From: Sue Howell <Sue.Howell@arun.gov.uk>
Sent: 08 February 2022 17:08
To: Michael Eastham <Michael.Eastham@arun.gov.uk>
Subject: Planning Consultation on: LU/369/21/RES

Application ref: LU/369/21/RES

Description: Approval of reserved matters following outline consent LU/47/11/ (amended under LU/182/15/PL) for the formation of the Central Wetland Area and the construction of the Central Spine Road running across the Central Wetland area, linking up Phase 5 and Phase 2B (also known as Phase 4). This site is in CiL Zone SP2 and is not CIL Liable as strategic site.

Comments – Revised 08/02/2022

TC2029_A06961-LA1-LA9.dwg

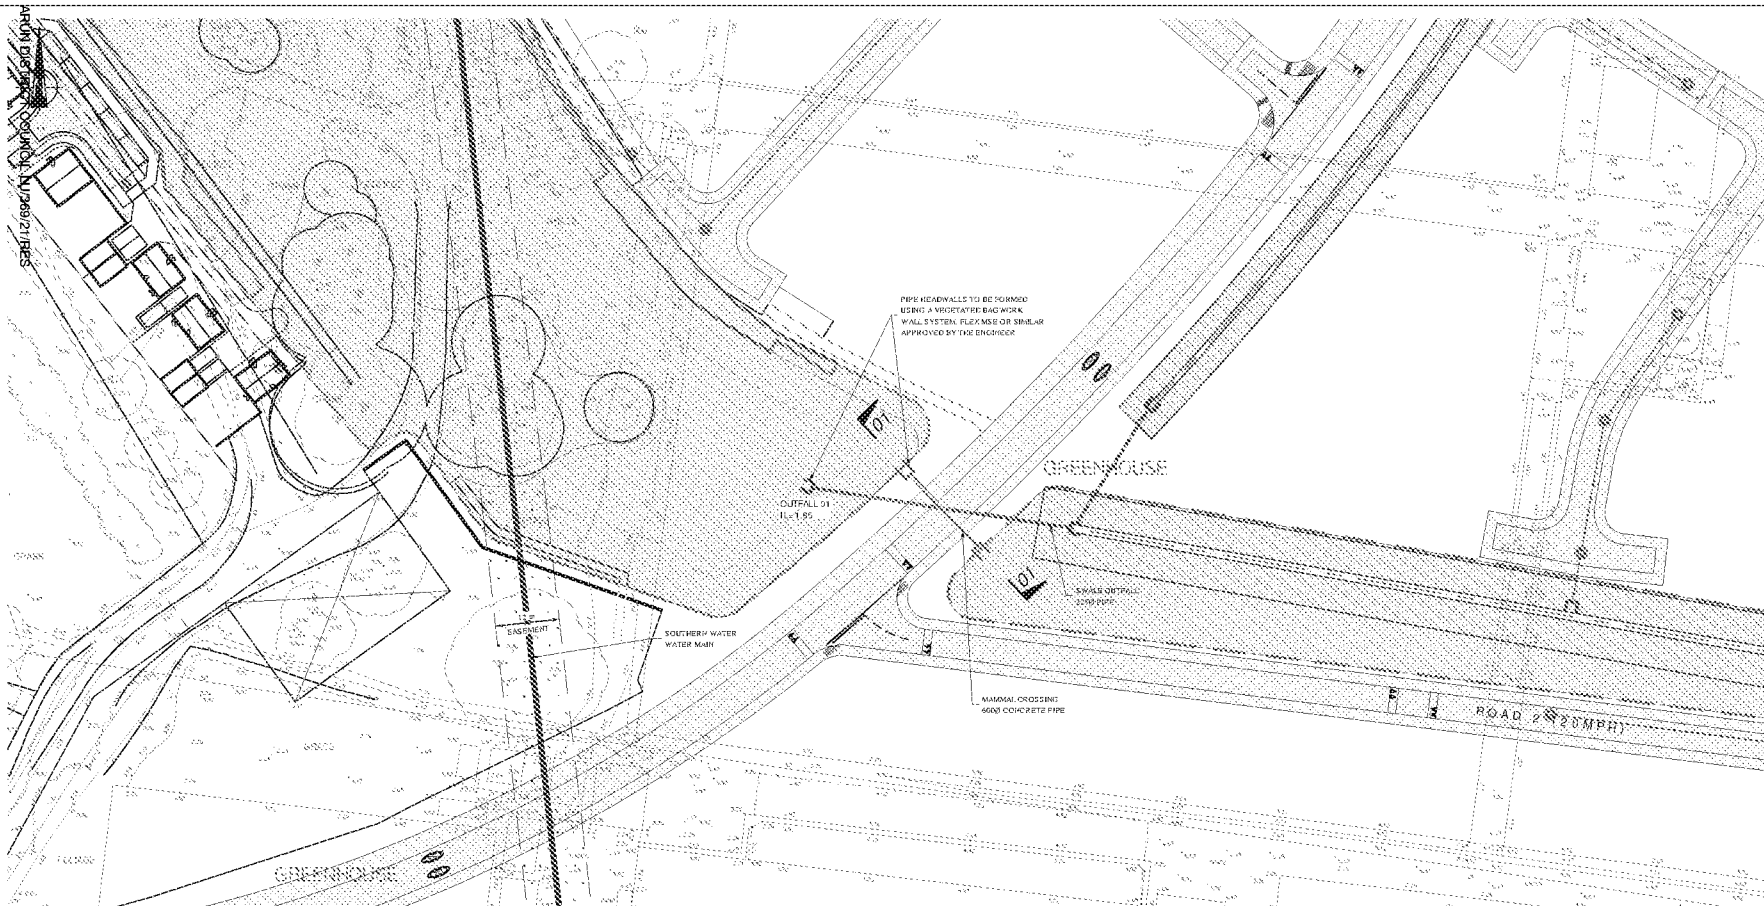
3. Reed bed planting/natural regeneration is indicated in several locations within the landscape drawings LA2 (Planting locations TC22029-LA1-LA9 dwgs) however no detail of replanting is detailed within the plant specification. Has it been assumed that these will naturally regenerate following the earthwork operations. The scraping, removal and recontouring of the

ground in the Central wetland area could preclude this from happening therefore the formal introduction with planting of reeds should be included and specified.

4. No marginal planting has been shown to pond areas shown as depressions for habitat. The planting of a suitable mix of marginals needs to be specified which will encourage wildlife and give these areas a purpose and aesthetic benefit.
